From: Matthew Chadwick
Sent: 08 January 2021 09:25
To: DC Support
Subject: FW: Planning notification for application reference: 20/03467/F

I am commenting on the above application from an arboricultural aspect.

Proposal – to build 9 dwellings

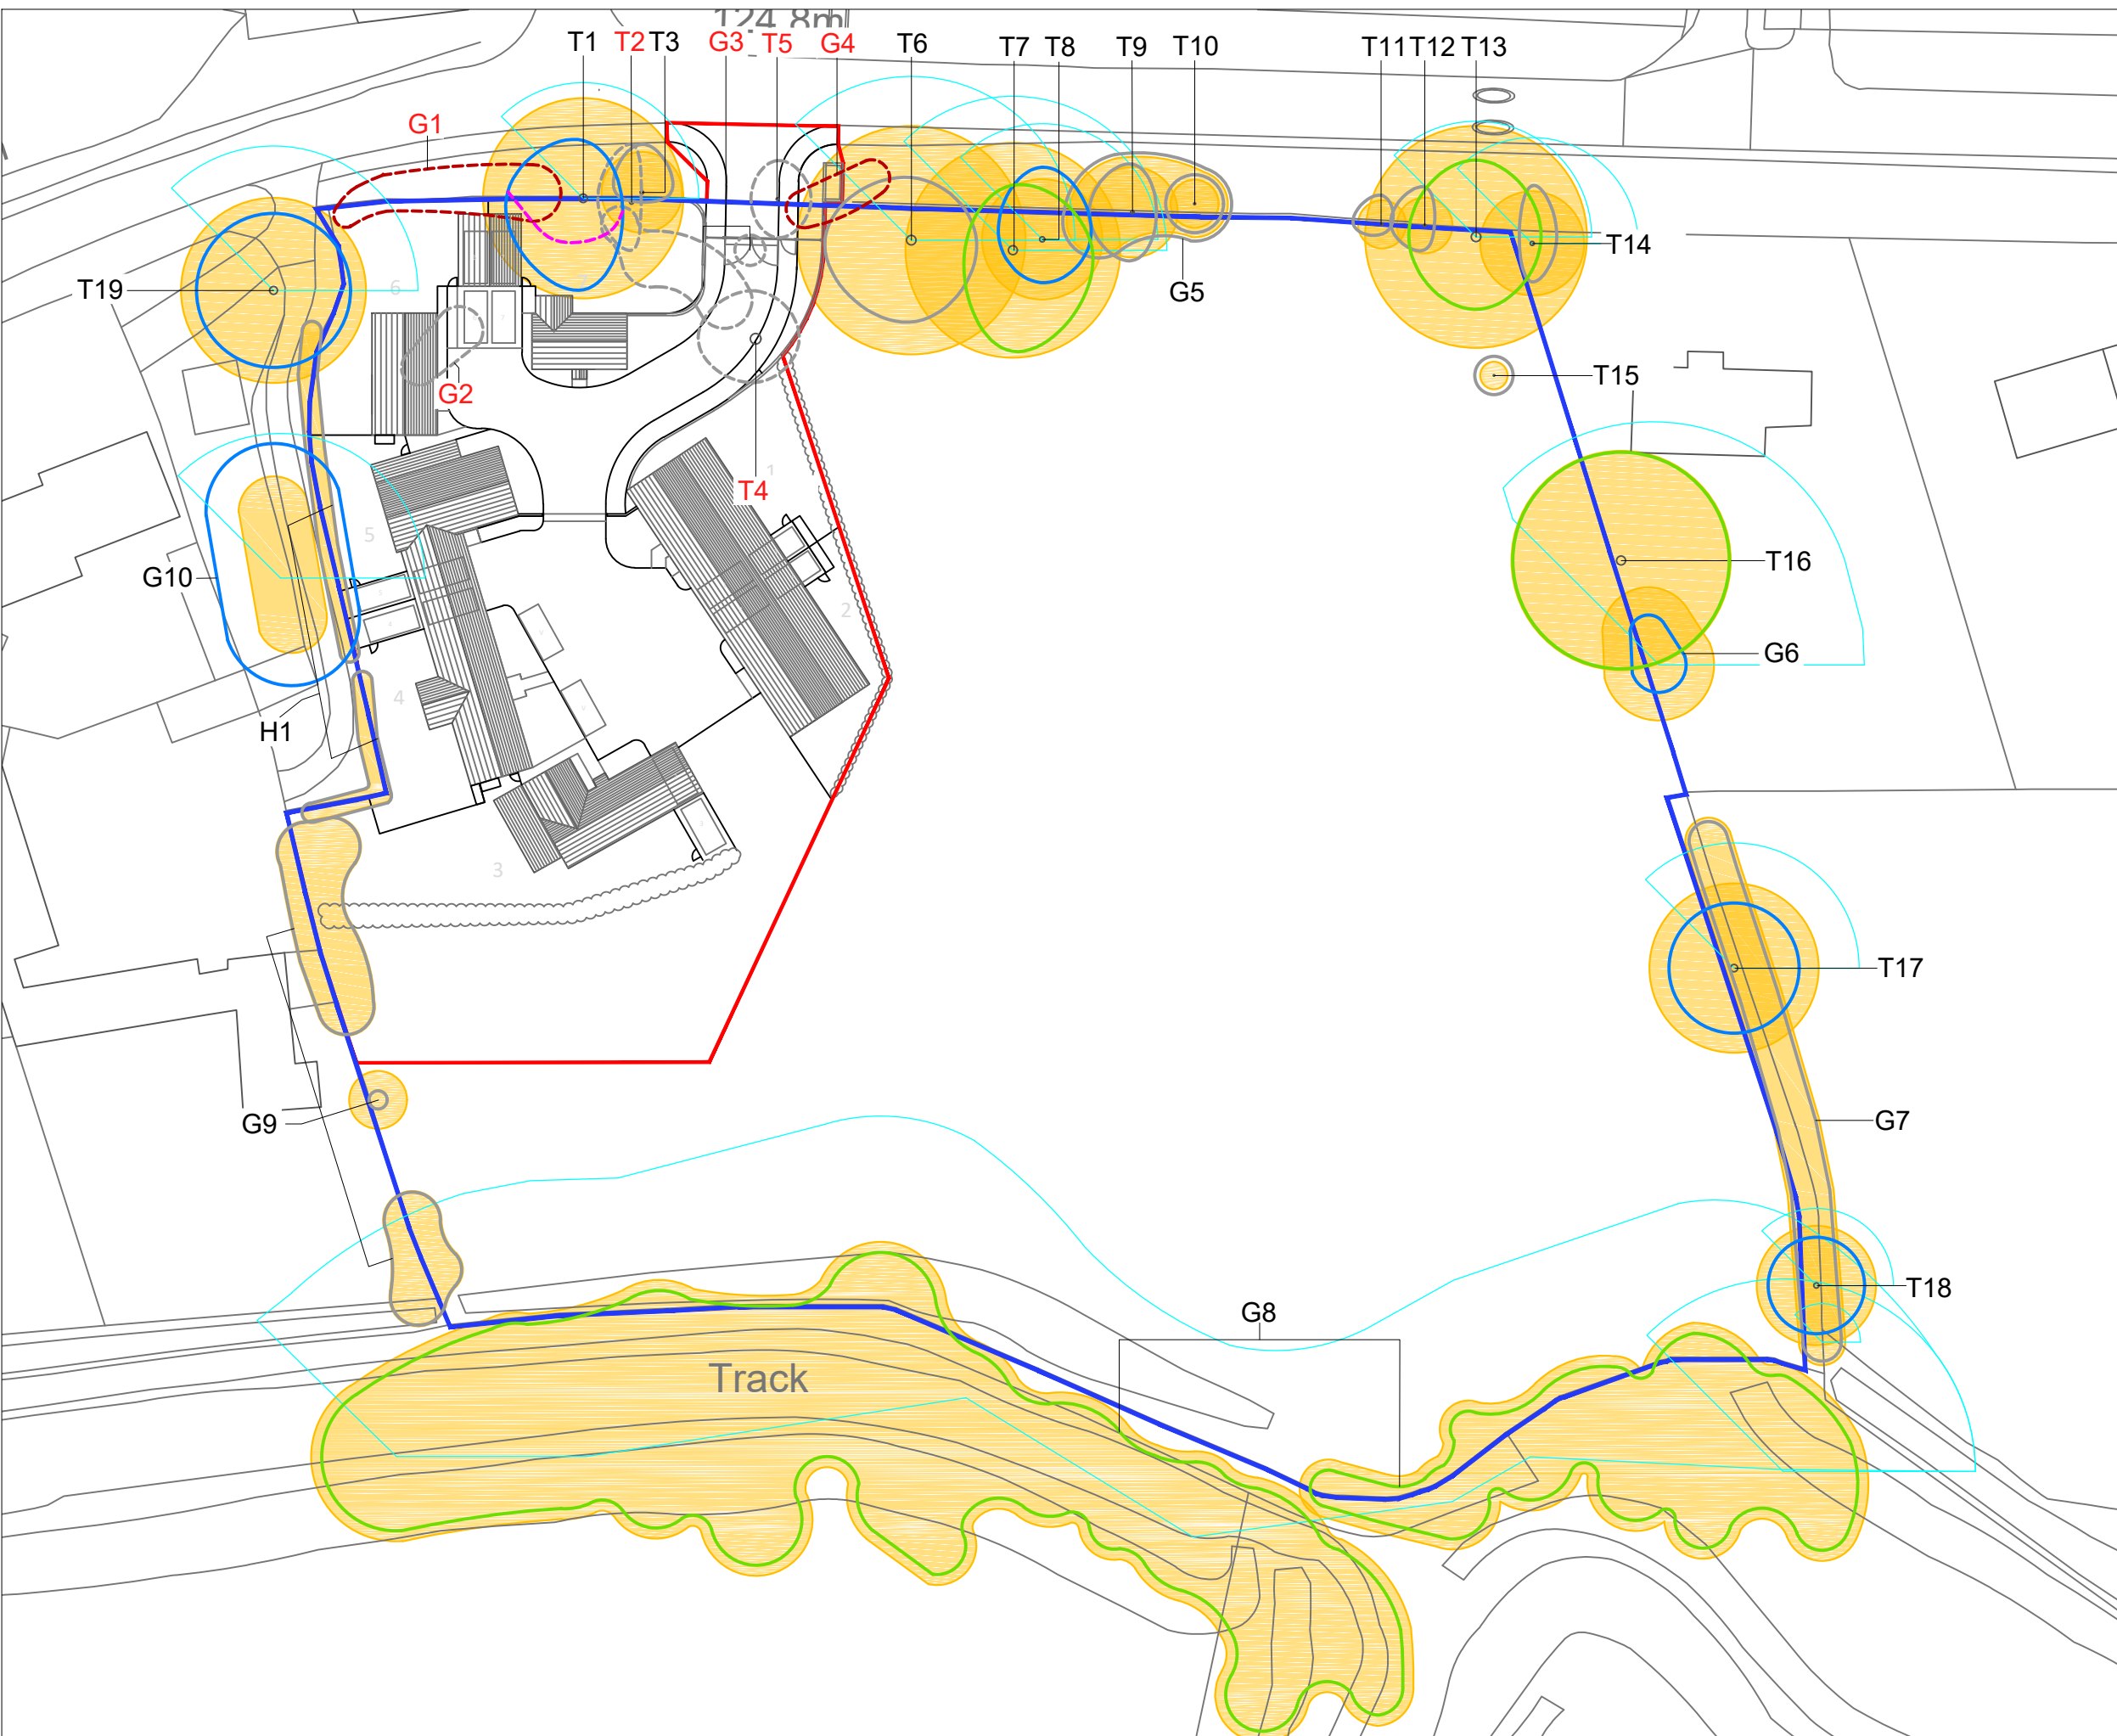
I was initially concerned about the encroachment into T1 as a B cat tree when it was feasible to develop outside the RPA since the incursion is only 3.2 %. It also required heavy pruning by 4 meters.

I then wanted to get the figures and impact plan. I get a larger RPA and more impact. I then checked T19 and it also shows a larger RPA which will be impacted.

Can you ask for the cad drawing of the Arboricultural Impact Assessment so that I can verify my findings and rule out any error on my part.
